WEST SUSSEX COUNTY COUNCIL CONSULTATION

TO:	Arun District Council FAO: Juan Baeza
FROM:	Alison Meeus, Highways, WSCC
DATE:	15/05/2018
LOCATION:	Spindlewood, Yapton Lane, BN18 0AS
SUBJECT:	<u>WA-33-18</u> Outline application with some matters reserved for the demolition of existing dwelling and erection of 5no. dwellings. This application is a departure from the development plan.
DATE OF SITE VISIT:	n/a
RECOMMENDATION:	☐ Advice ☐ Objection ☐ Modification ☐ No Objection ☒ More Information ☐ Refusal
S106 CONTRIBUTION TOTAL:	£ See below for breakdown.

Drawing.
Proposed Site Plan
showing Swept Path Path
and Parking Provision

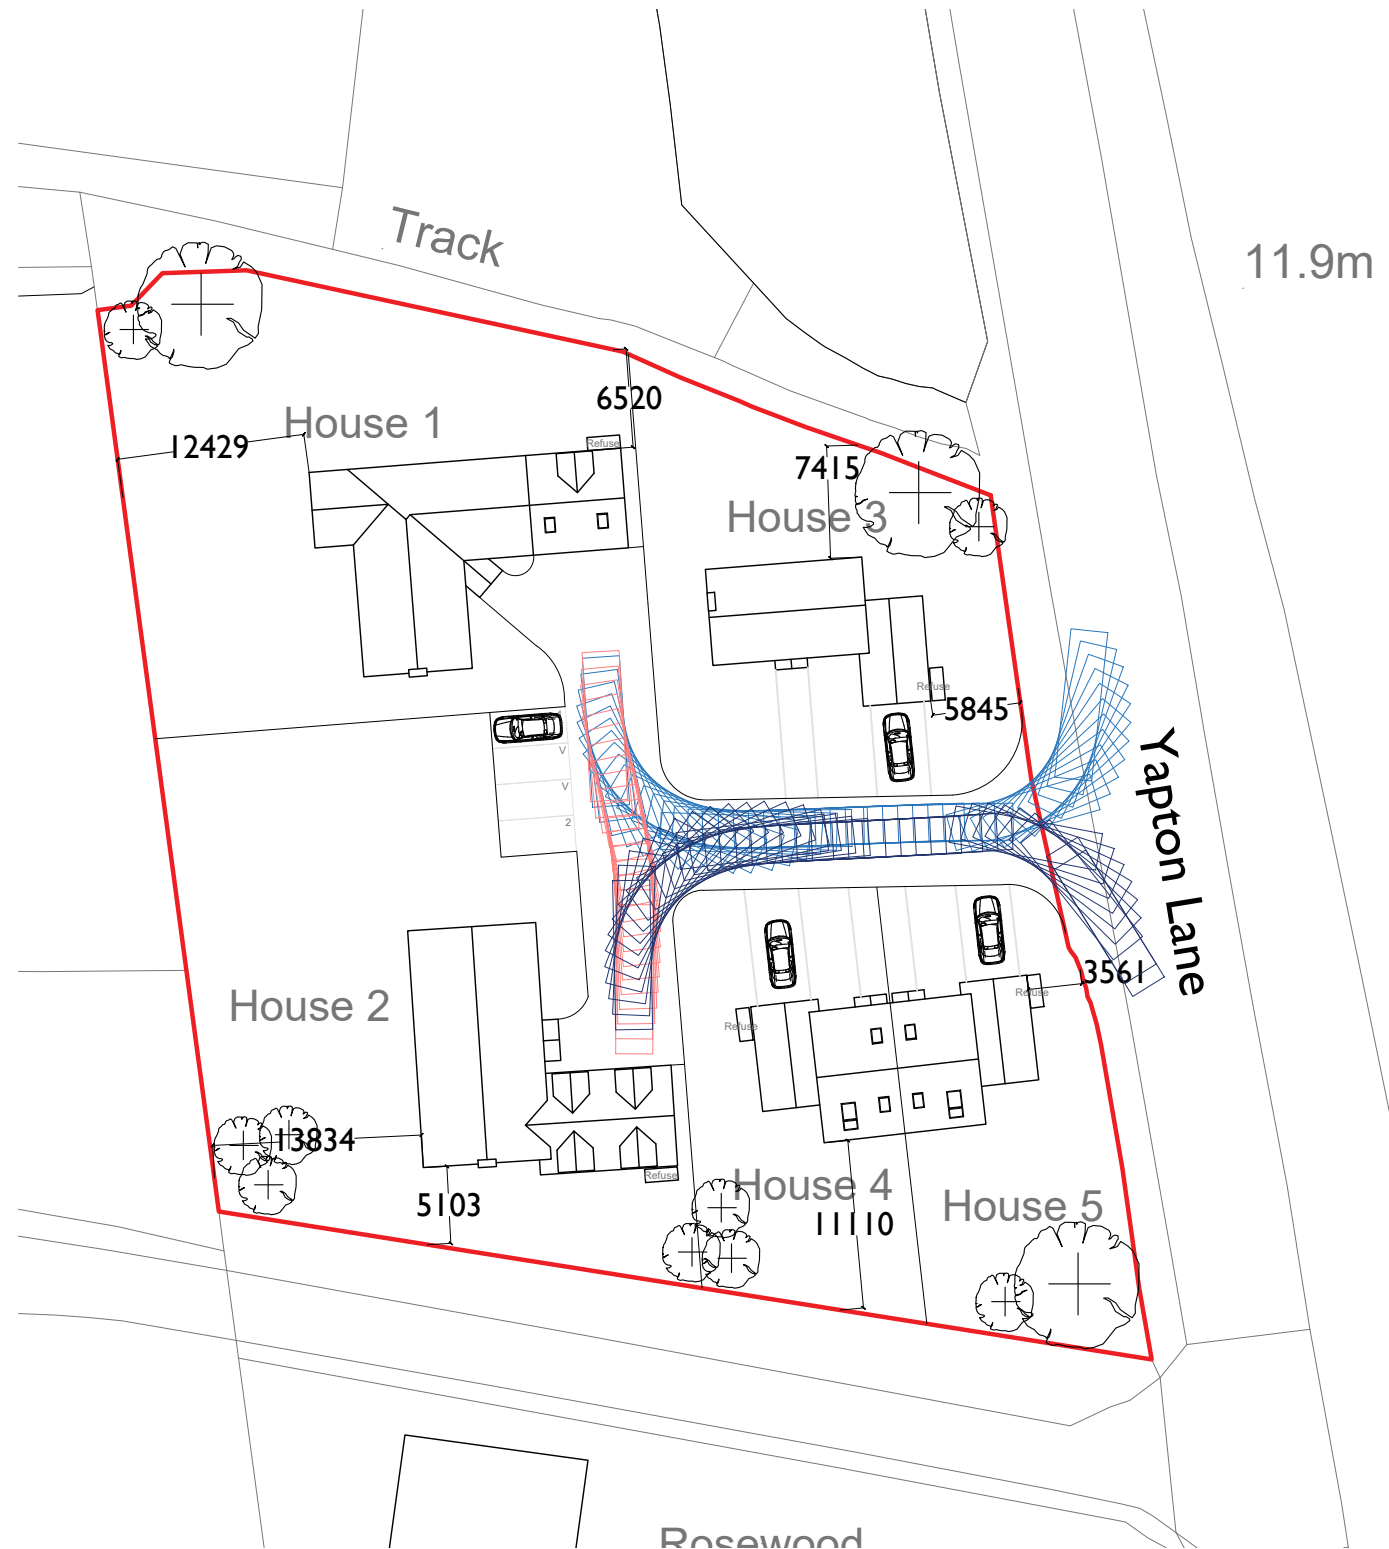
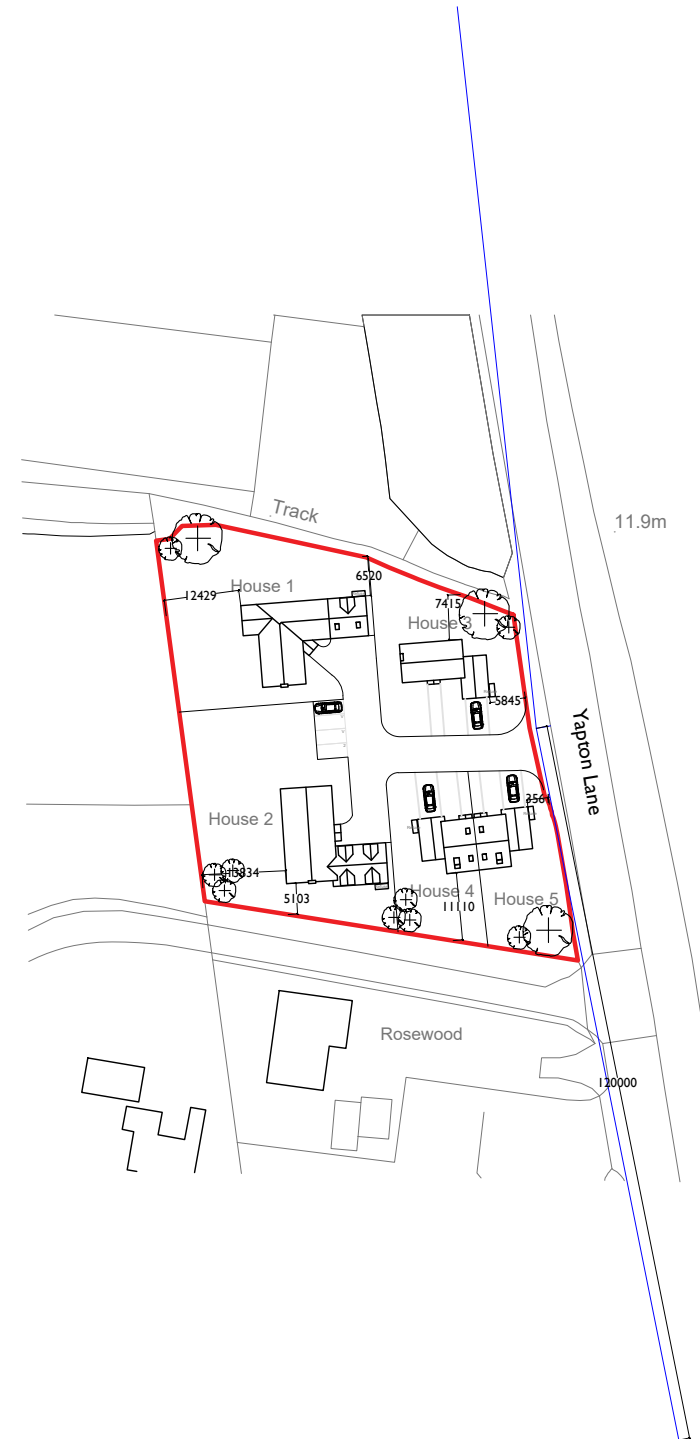
The site is currently accessible from a small driveway located at the north eastern edge. The proposal to re-locate this access will provide a more central position, as per drawing DPA 02 Rev A. Details on the plan are limited but show the access will be 6m in width and a turning head created so a vehicle can exit in forward gear.

No visibility splays are shown the site plan and the access should be able to provide good visibility in both directions. Yapton Lane has a straight alignment and visibility splays should be provided in line with DMRB of 2.4m x 120m in both directions. Should there be a departure from these standards due to the nature of the road this can be mitigated by undertaking a speed survey to understand what the design speed of the access could be. Considering there will an increase in the number of dwellings, from to 1 to 5 the access will need to be an improvement on what is already in place and at the very least provide the visibility splays for the speed of the road.

More detail is required including a topographic survey. The plan does not include footways and appears to be laid out as a shared use space. This would tie in to the

existing layout of Yapton Road which does not have any footway connections. Given it is a small development a shared use layout would be acceptable. Mfs 7.2.14 state subject to making suitable providing for disabled people, shared surface streets are likely to work well in short length where they form cul-de-sacs. Consideration to service margins and the telegraph pole will need to be included in further plans.

How will the site be serviced? It is assumed the site will be serviced internally. If this is to be the case please can a swept path diagram be provided to show a refuse vehicle and/or fire appliance using the site. These need to show how they will use the proposed access turning in and out; and also the turning circle (or dimensions to show this is large enough for the size of refuse vehicle.

WSCC car parking standards in residential developments are based on an allocated or non-allocated basis. Given this is a small development with 3 and 4 bed homes parking can be allocated to each plot. A 4 bed home would normally command 3 + spaces and a 3 bed home 2 spaces. Therefore we would expect to see parking for at least 12 cars plus 2 visitor spaces, as per the attached WSCC car parking calculator.

The parking plan needs to show where these spaces will be located and if this affects the road layout, especially if visitor spaces are included in the proposal.

2. Updated drawing to show visibility splays from new access location/existing access to compare the changes
3. Car parking strategy
4. Layout issues addressed
